# Land south of Newfoundland Road, Deepcut

Ref: ITS19098-001C Reserved Matters Transport Statement  
Date: 13 November 2023

## SECTION 3 SCC Pre-Application Comments

APPENDIX C. VERTICAL ALIGNMENT OF ACCESS

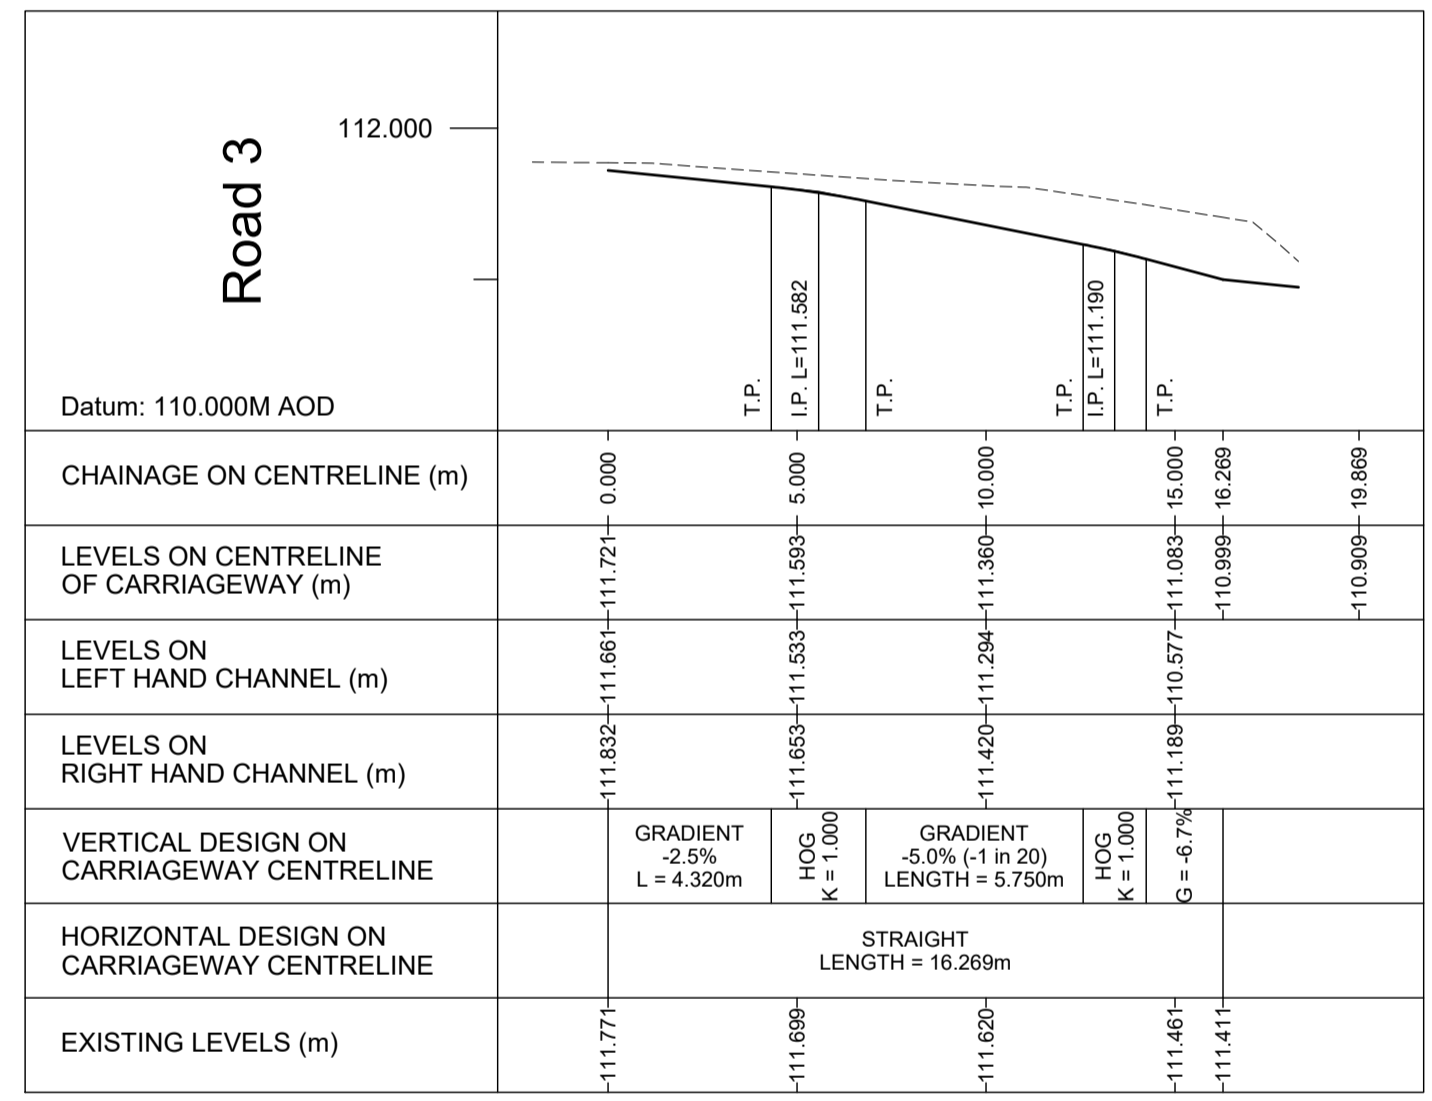
7. Provide hardstanding at parking by verges.	Agreed.
8. Show gradients on plan.	Agreed. Chainages and long sections are shown in engineering drawings in <b>Appendix C</b> .

4.2.6 The transitions in gradient on the access ramp will have a K value (measuring the rate of change of curvature) of 1, which is appropriate for a design speed of 20mph (ref: SCC’s design guidance *Technical Appendix A, table on page 20*). A drawing illustrating the vertical alignment of the site access is included as **Appendix C** and is reproduced below.

APPENDIX D. ACCESS VISIBILITY SPLAYS

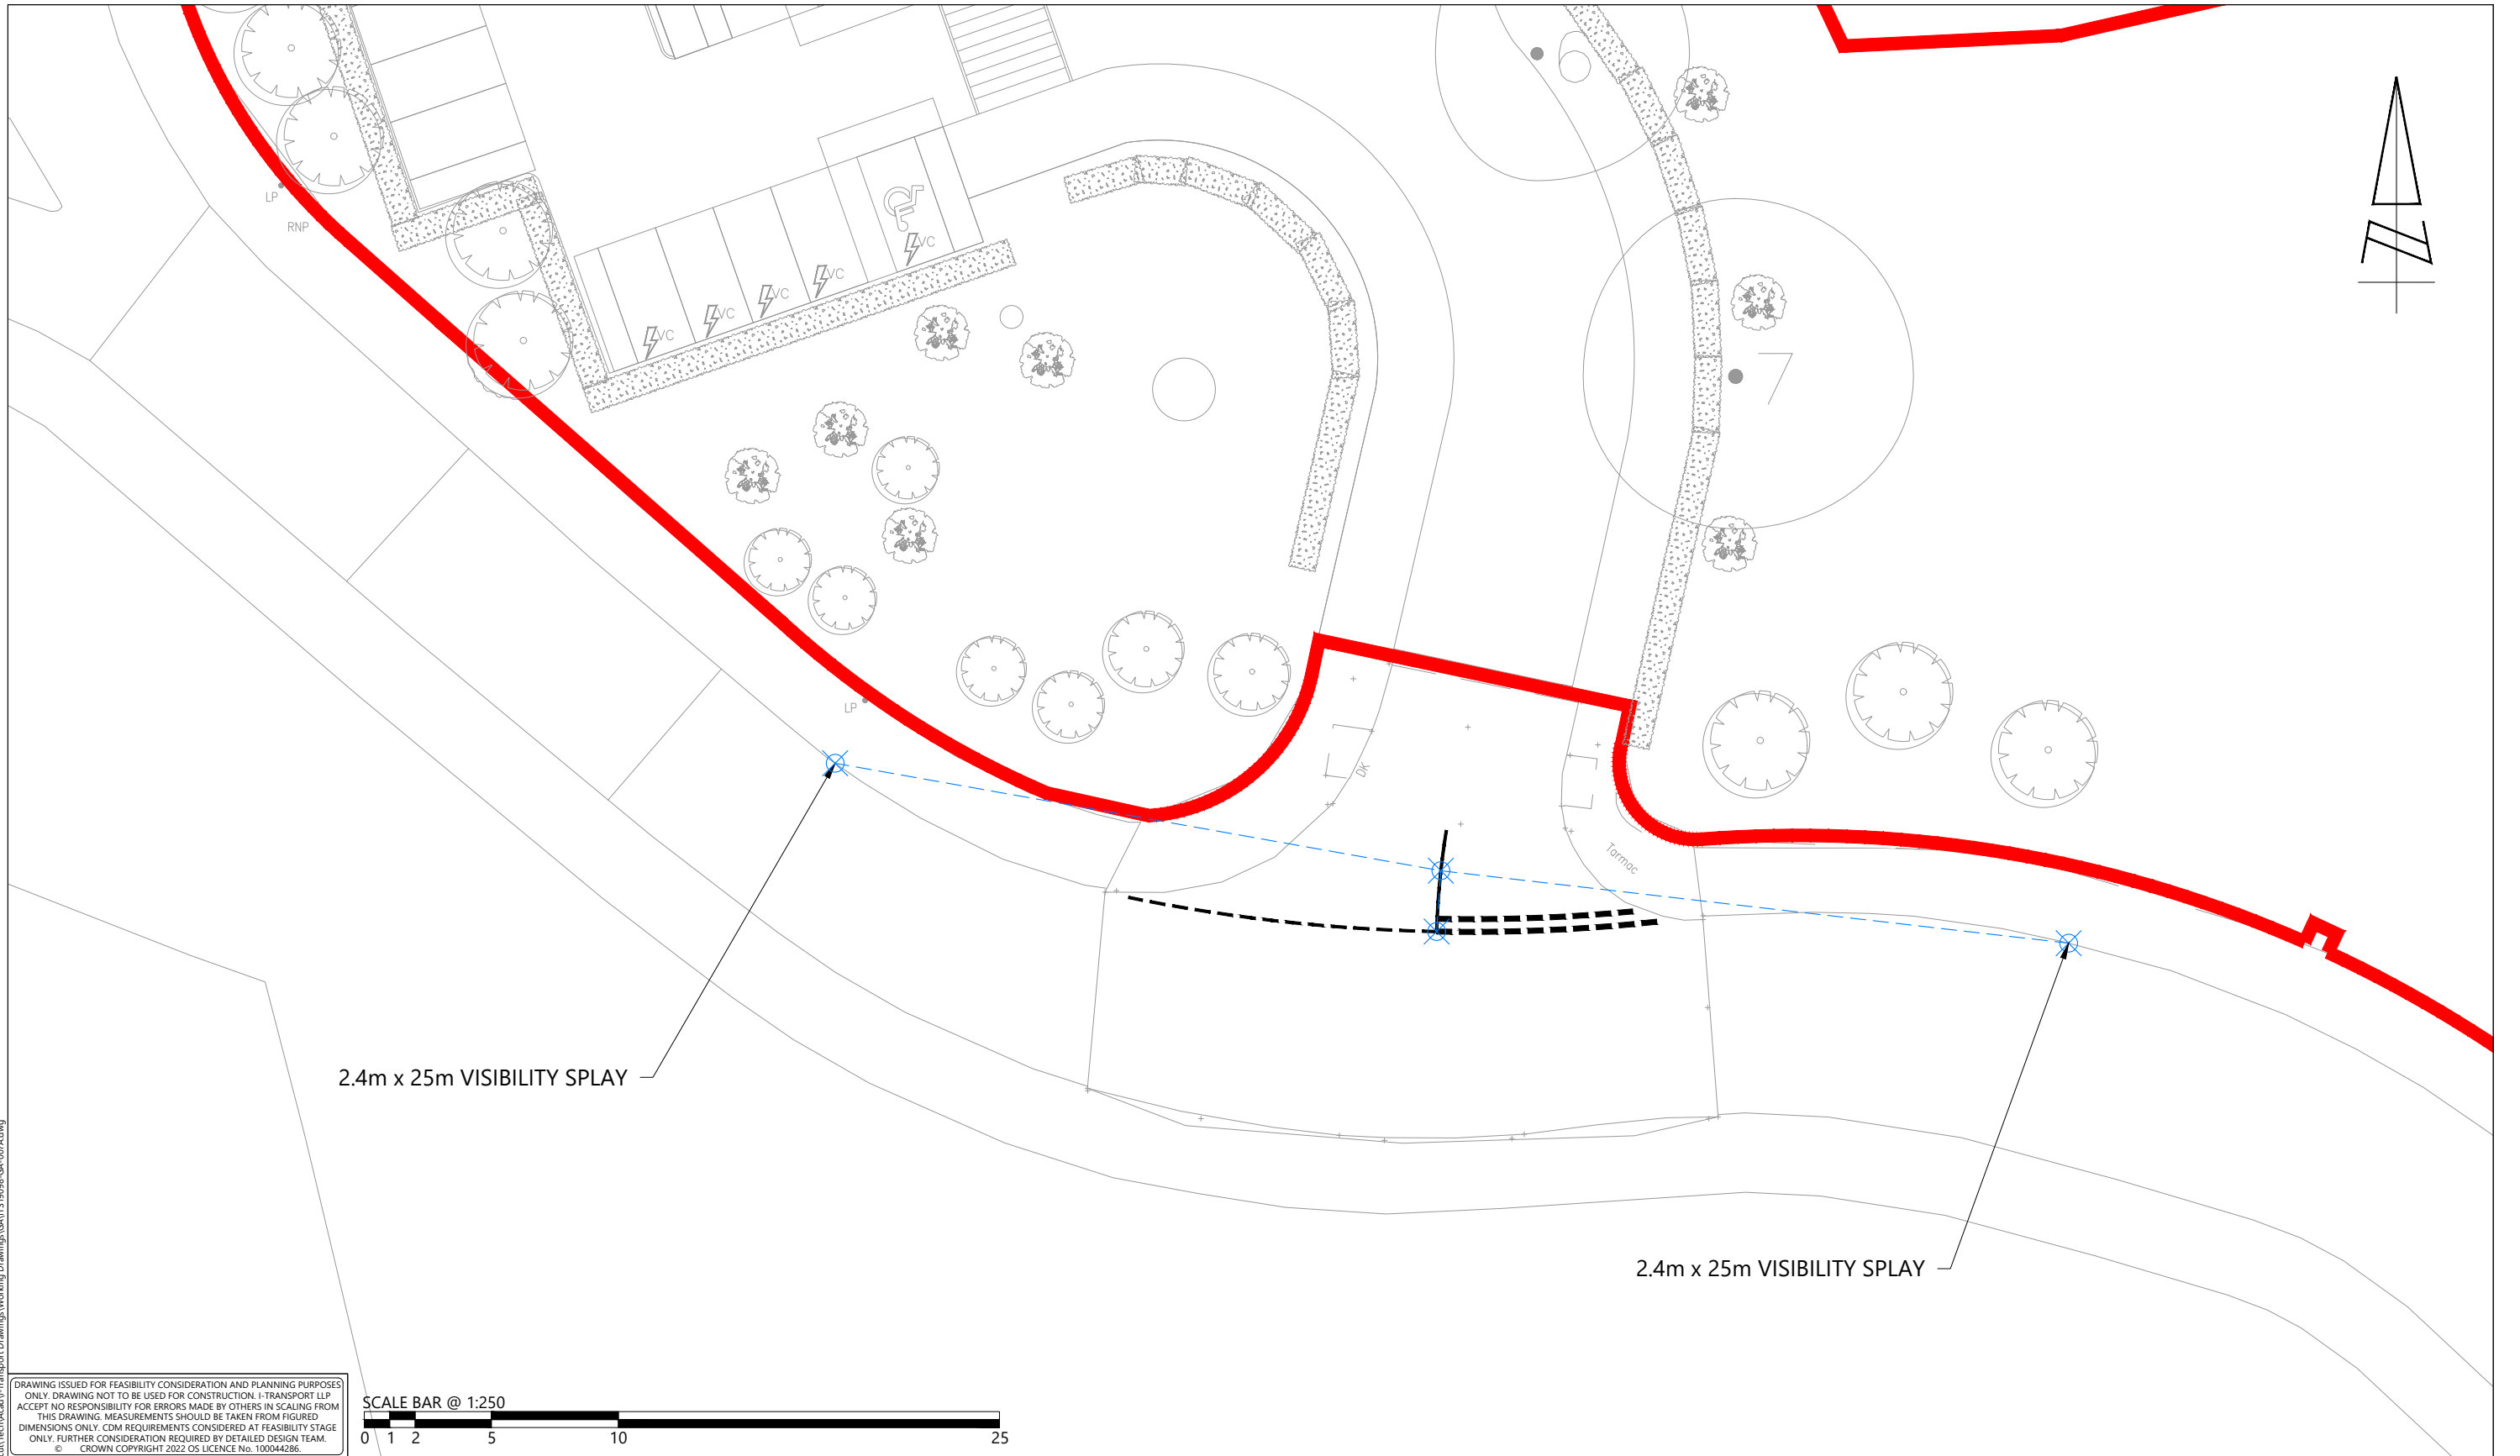
- 2.5.1 Condition 23 of the planning permission requires that all proposed vehicle and cycle accesses be designed, constructed and provided with visibility zones in accordance with details submitted to and approved in writing by the Local Planning Authority.

4.2.3      Condition 23 of the outline planning permission requires accesses to be designed and constructed with appropriate 'visibility zones' Whilst the access has been constructed, this information has been provided for completeness. Visibility splays from the access junction, measuring a 2.4m x 25m, are achievable as shown below and at **Appendix D**.

APPENDIX E. SERVICE VEHICLE SWEEP PATH ANALYSIS

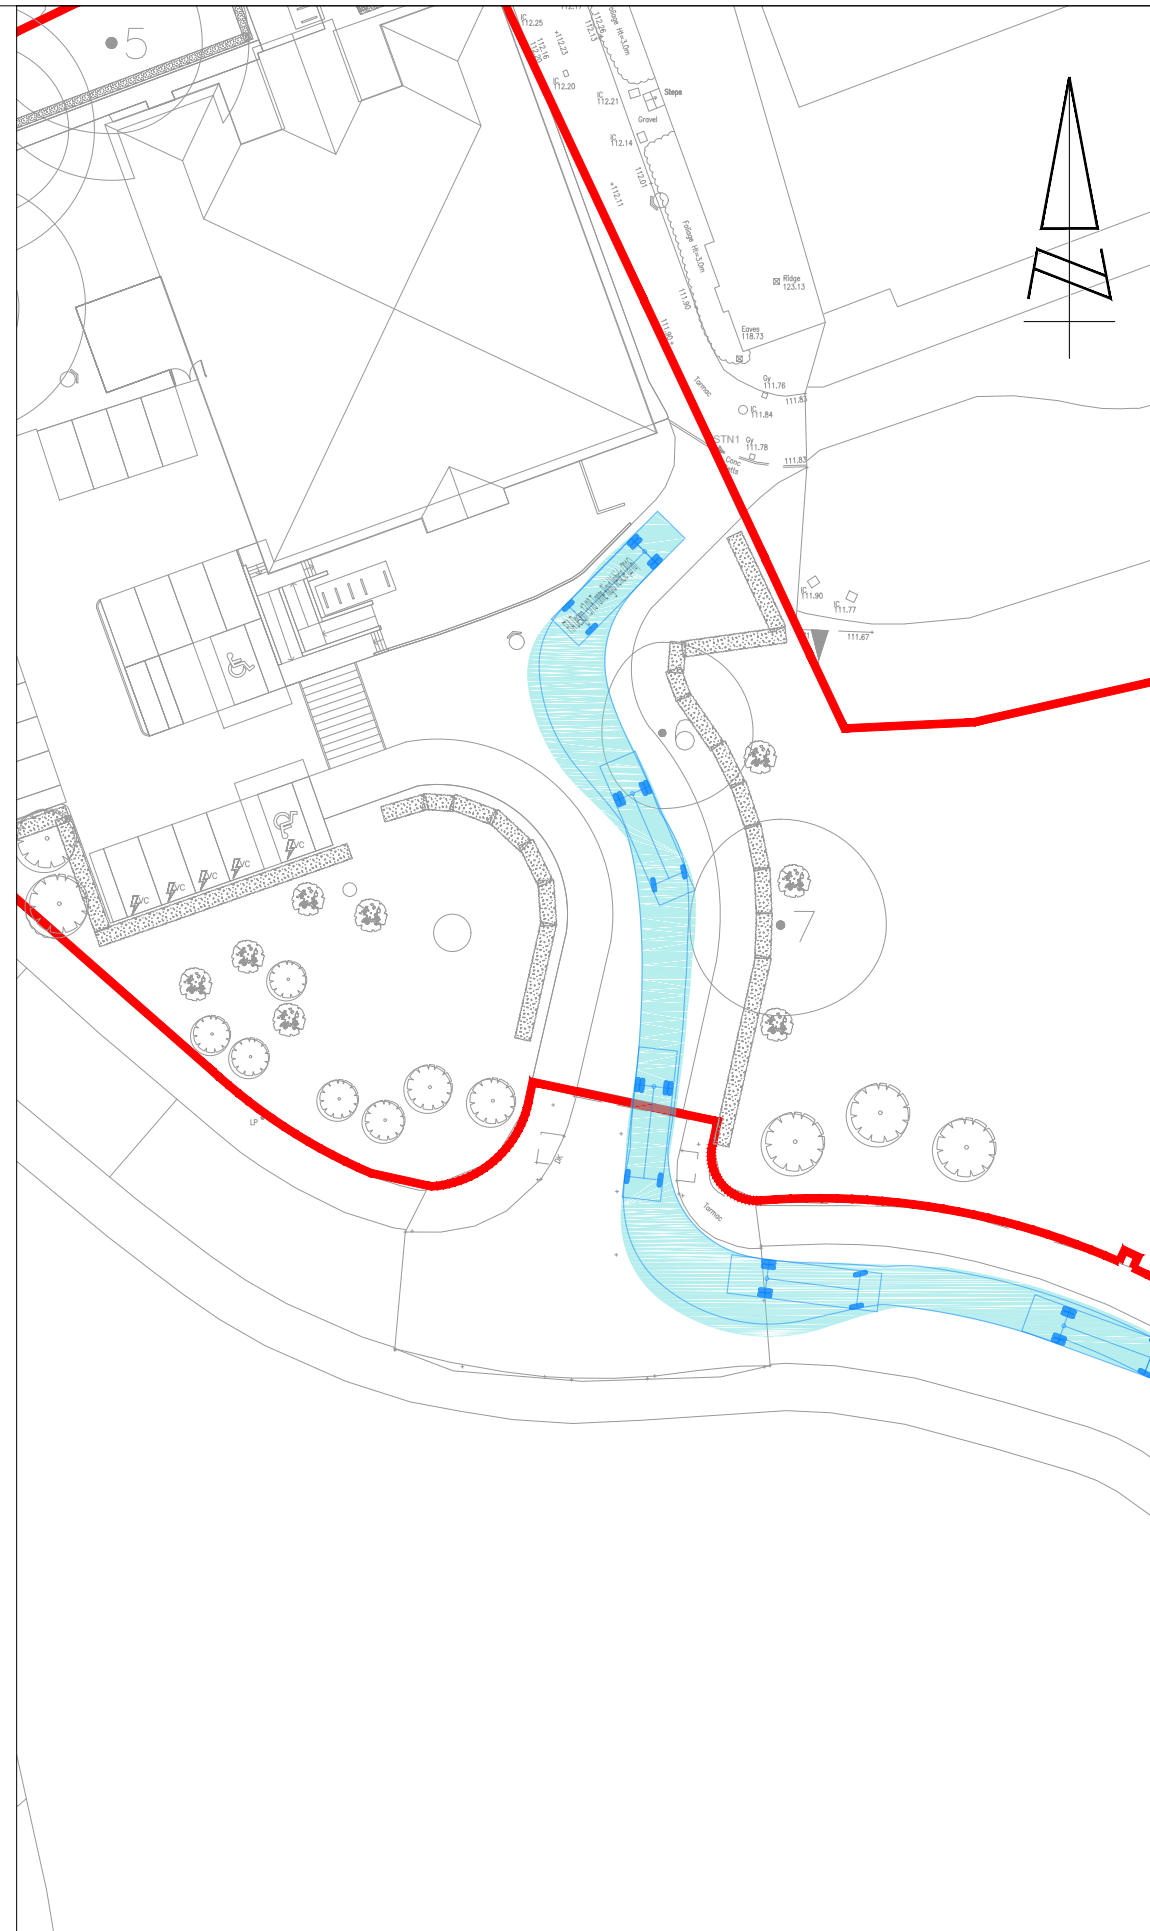
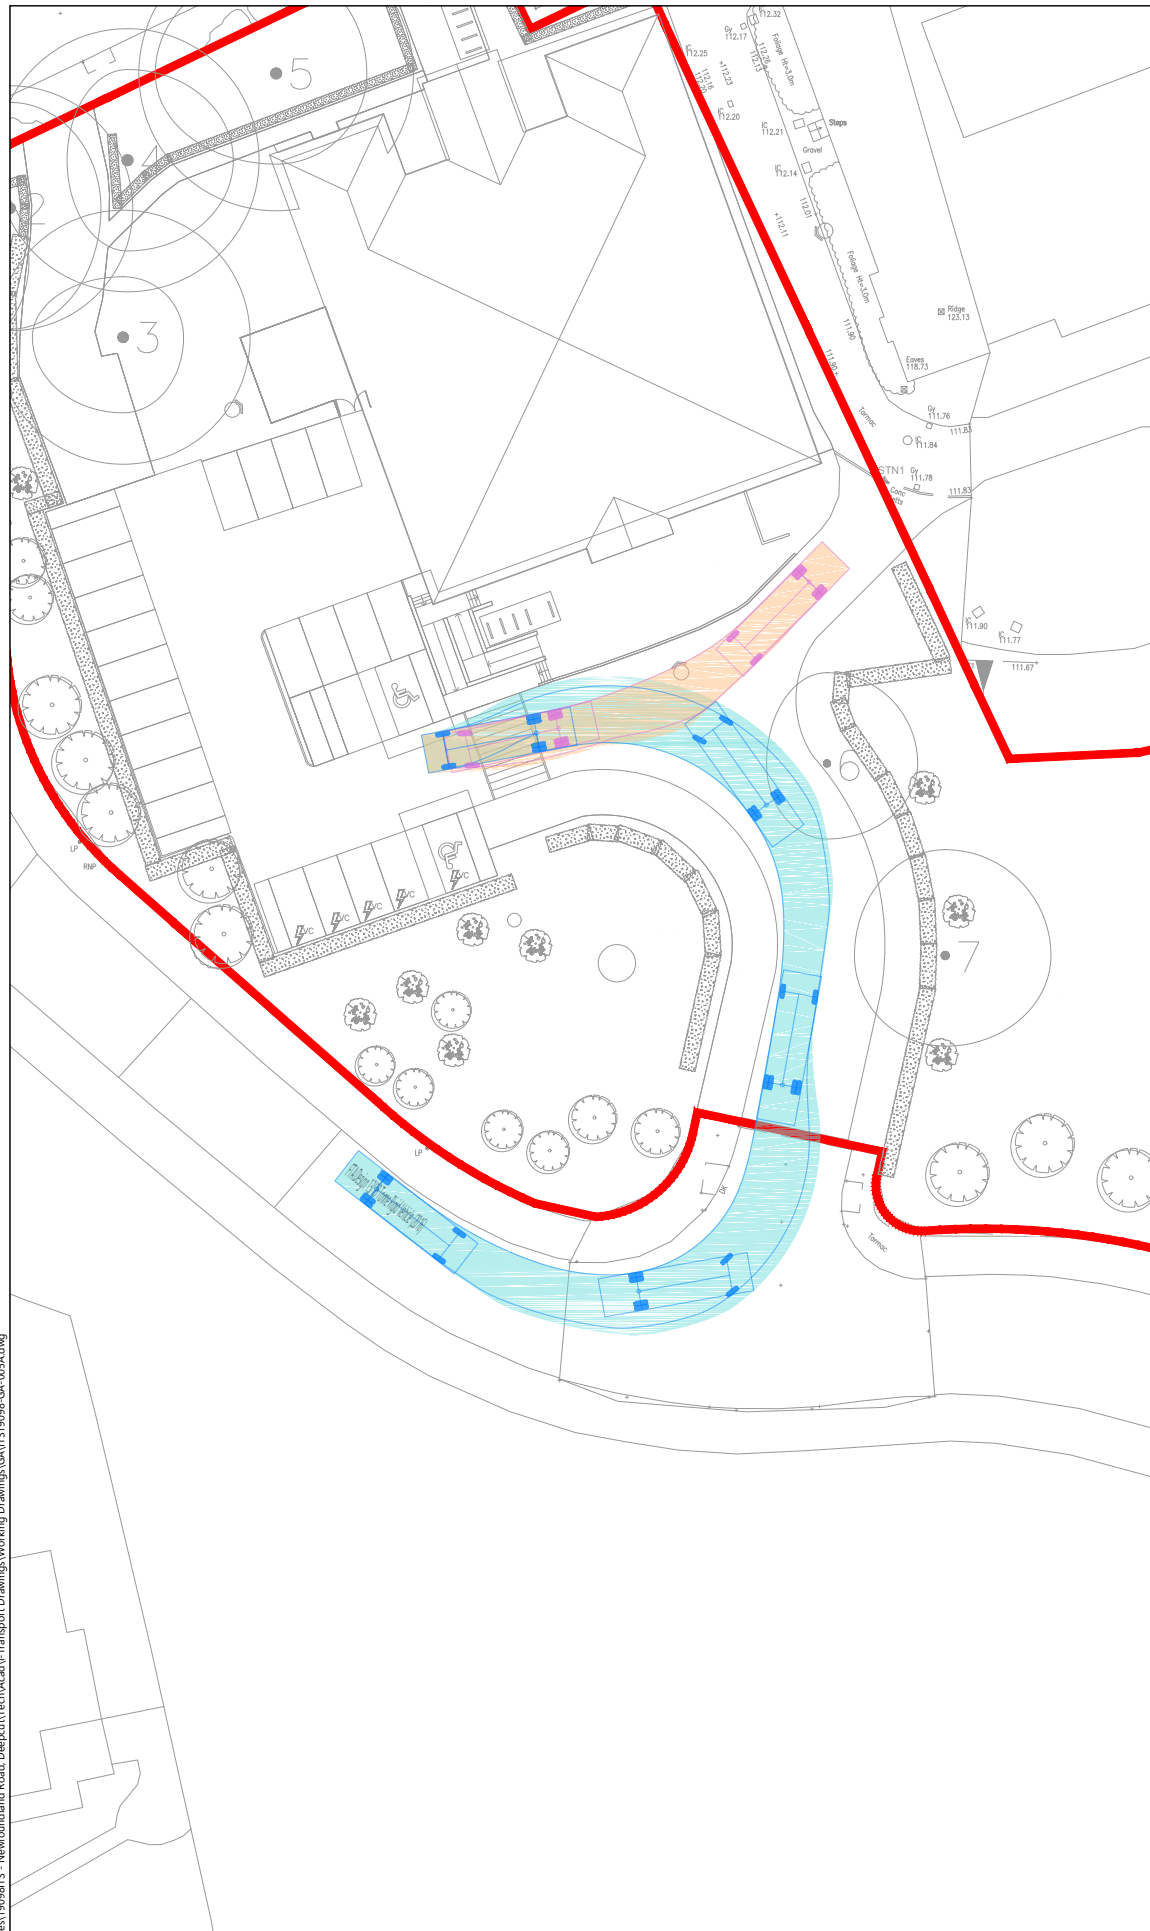
12. Provide swept path analysis	Agreed. See section 4.
13. Provide 4m wide flat crossing in front of store	Agreed. As shown on the engineering drawings, there is minimal gradient in this area.

4.5.4 A 10m rigid vehicle is the largest expected delivery vehicle to an Asda convenience store. The same type of vehicle will also take away retail waste. A swept path analysis has been undertaken to demonstrate that a 10m rigid vehicle can safely access and egress the service yard in such a manner as to enable turning on the highway in a forward gear. An extract of this is presented below and in **Appendix E**.
